Sent: 27 August 2009 16:23
To: Planning
Subject: Welwyn Hatfield Council Online Planning - Comment

Application Number: S6/2009/1794/LB
Name: simon cadisch
Address: the vines
essendon
herts
al96hs

PROPOSED PLANS & BLOCK PLAN

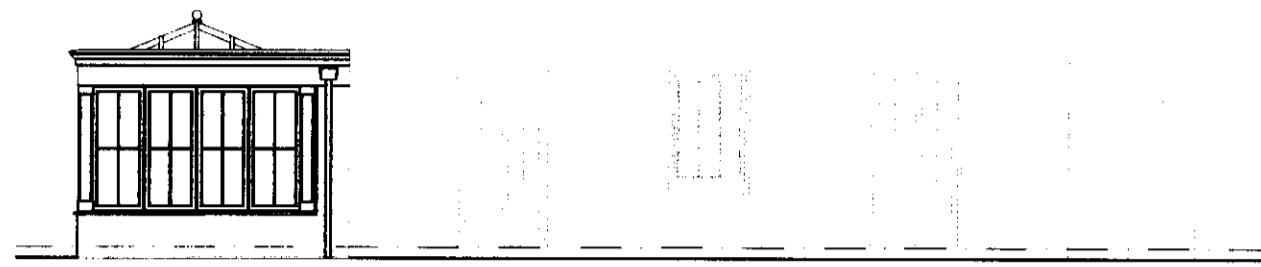
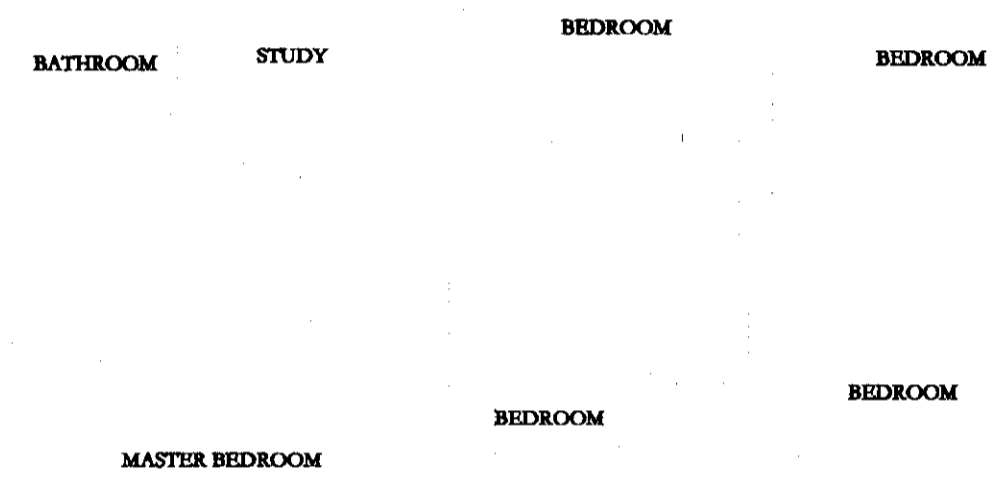
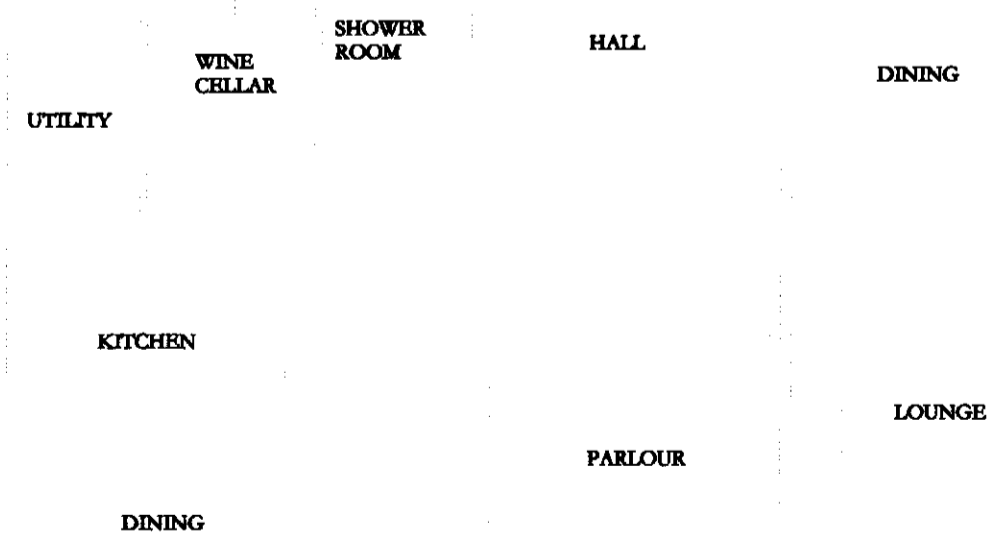
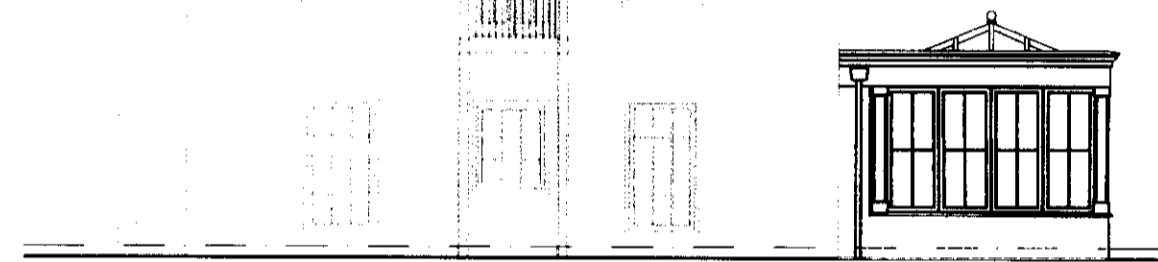
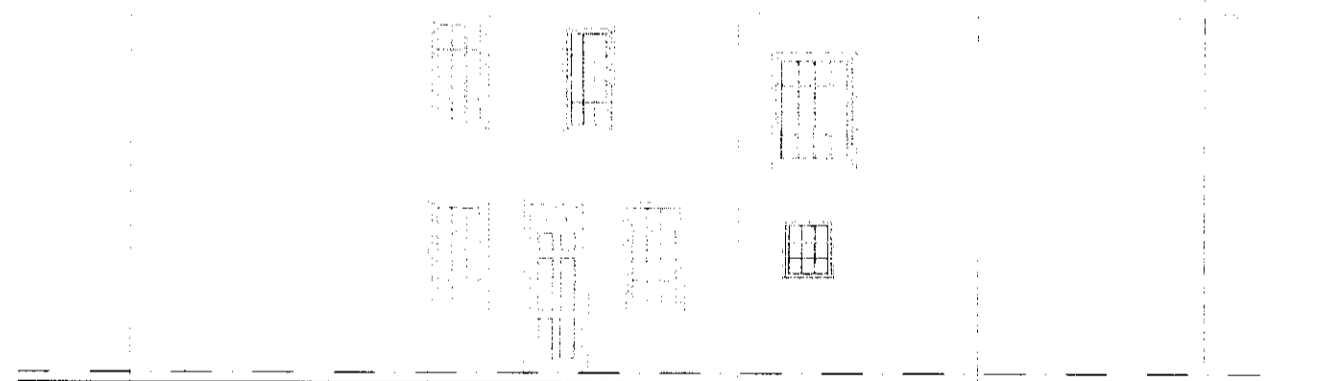
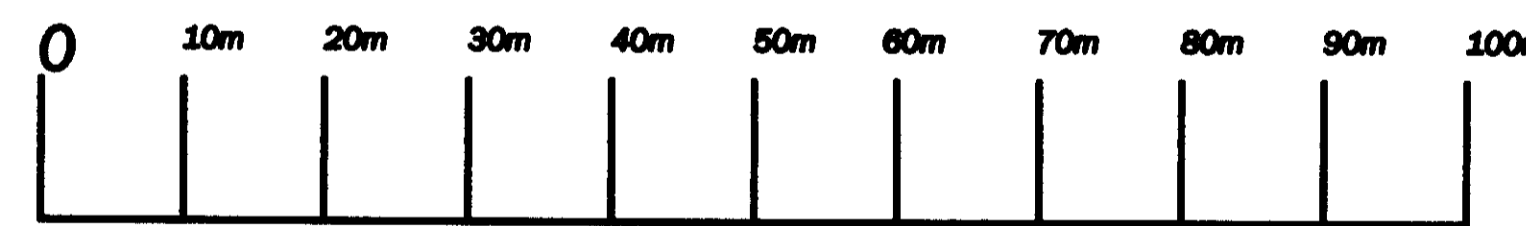
This new application requests another very significant addition to the already much enlarged footprint of the building (by my estimate another 30%) which contravenes planning guidelines as well as looking out of proportion to the rest of the dwelling. The application suggests that this new addition would not be visible from the public highway but this is not correct.
